PAVEMENT DESIGN REPORT

**Copper Chase at Sterling Ranch, Filing No. 1
Phase 1
El Paso County, Colorado**

JOB NO. 193596

February 26, 2024

SHEET No. FIG-2.1	TEST BORING LOCATION PLAN
	ENGINEER DRAWN BY: NM CHECKED BY: TM (SQUEL) 2-26-2024

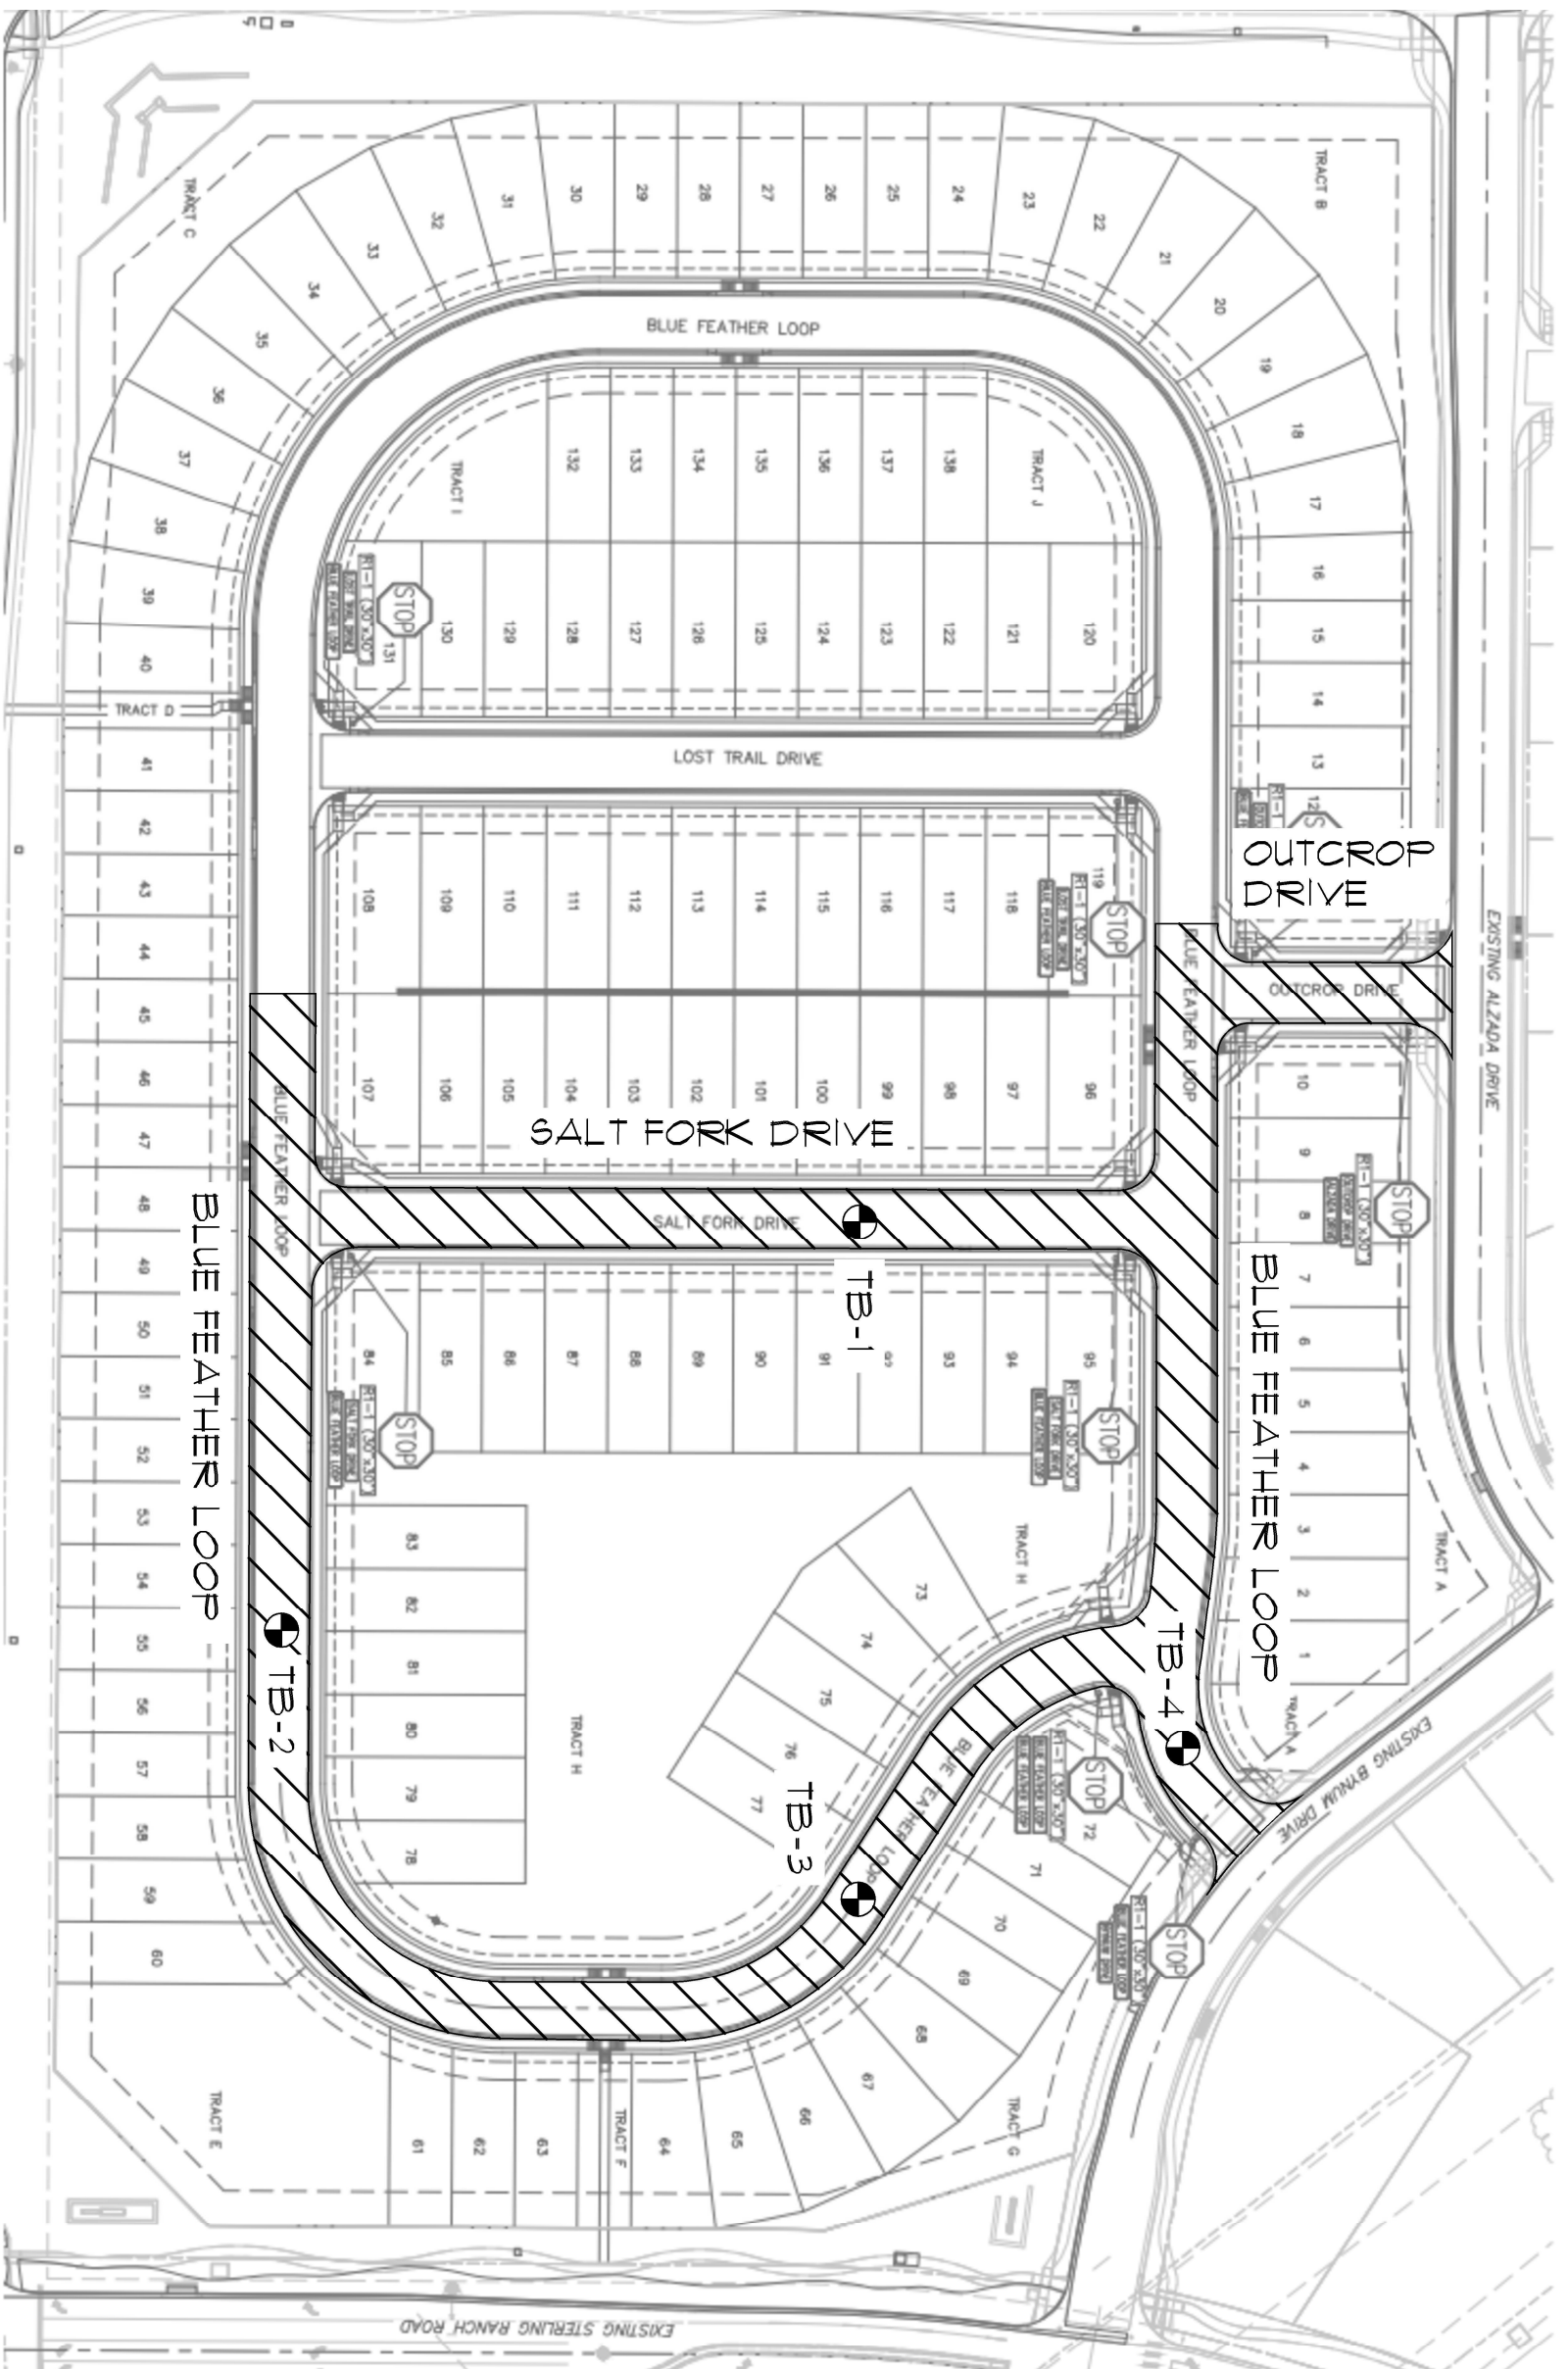
Label road classification and ESAL value.
